Elena Sliogeris
Department of Planning and Environment
Via Major Projects Portal

SSD-49472213 SUBMISSION - OBJECTION

Thank you for the opportunity to comment on the abovementioned State Significant Development Application (SSD-49472213). This submission has been prepared by SP13518, located at 81 Gerard St Cremorne, NSW 2090 in relation to SSD, which seeks consent for:

1 NORTH WEST ELEVATION
(GERARD STREET)

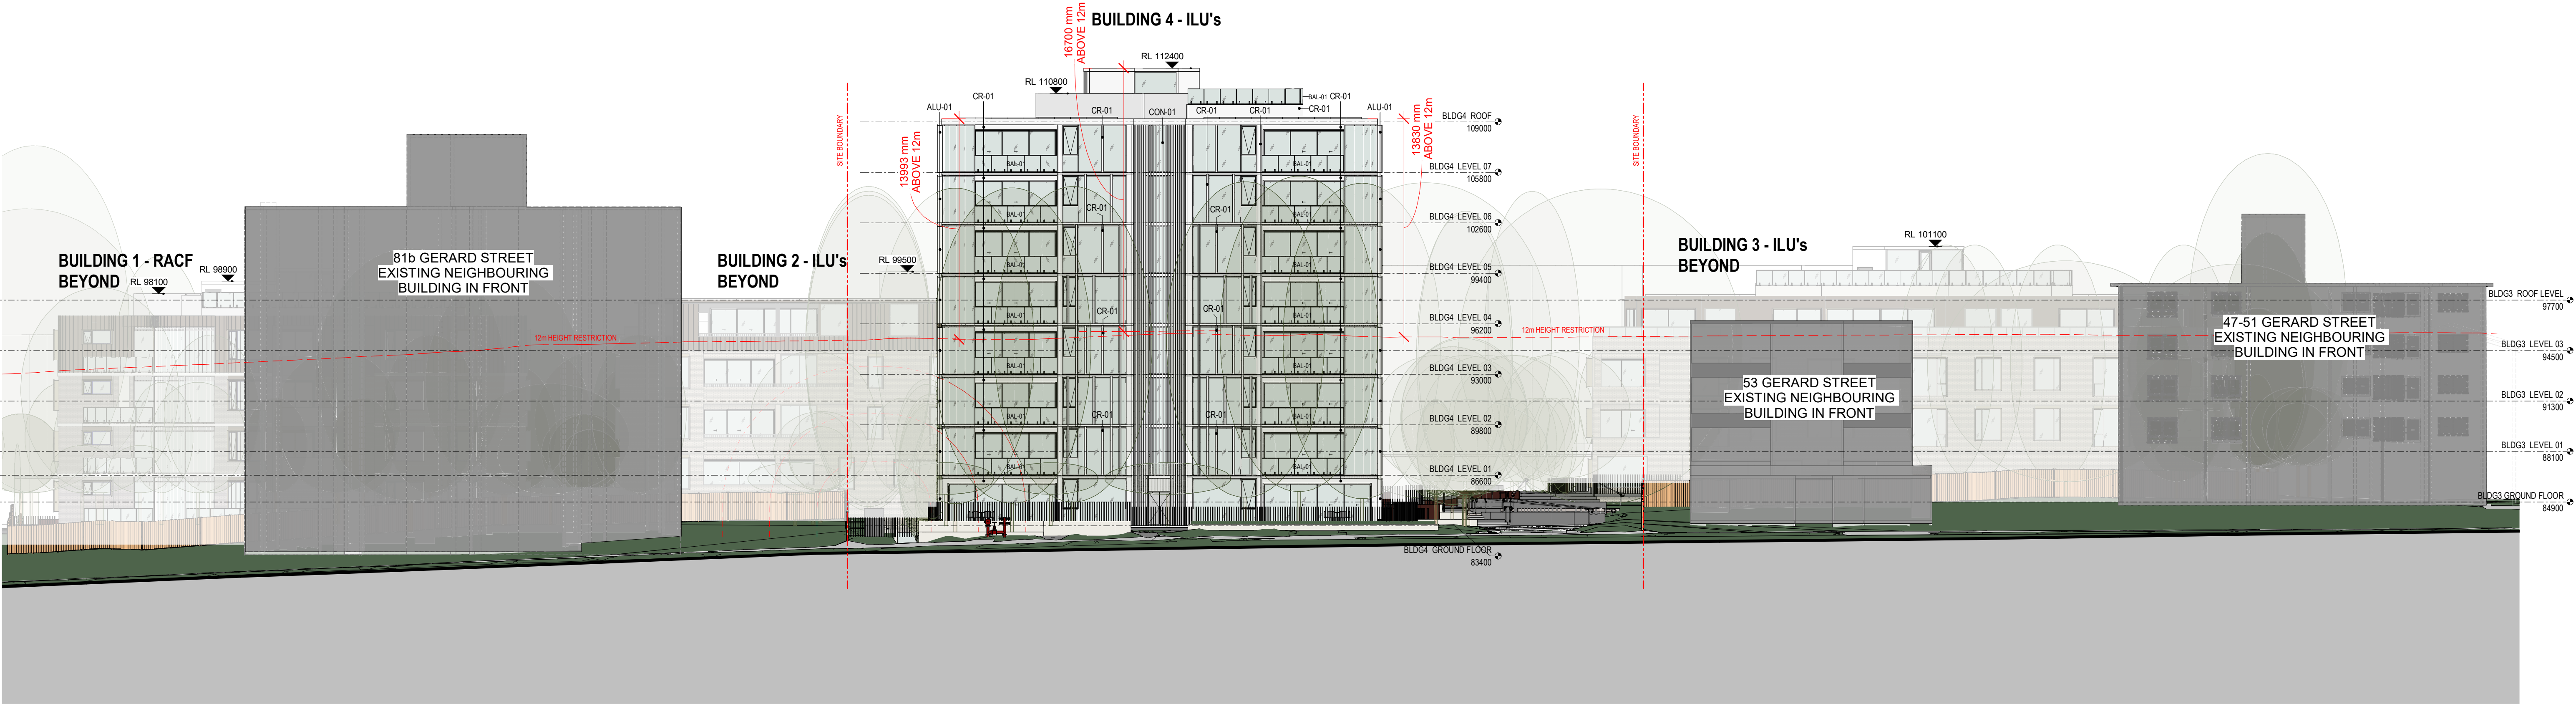
The proposal places a large quantum of bulk and scale within the northern portion of the site, namely in the form of building 4, which exceeds the applicable building height controls for the site by a variation of 139%. A large emphasis has been placed on justifying this breach through 'existing character', where the applicant alleges multiple developments along Gerard Street are between 4-15 stories. This statement is false for the following reasons:

Building 4 represents a significant breach of the applicable building height controls, resulting in unreasonable bulk and scale on Gerard Street. The environmental impacts which result from this built form have not been adequately assessed, nor mitigated, by the applicant. The height should therefore be reduced to more closely align with the development controls which apply to the site.
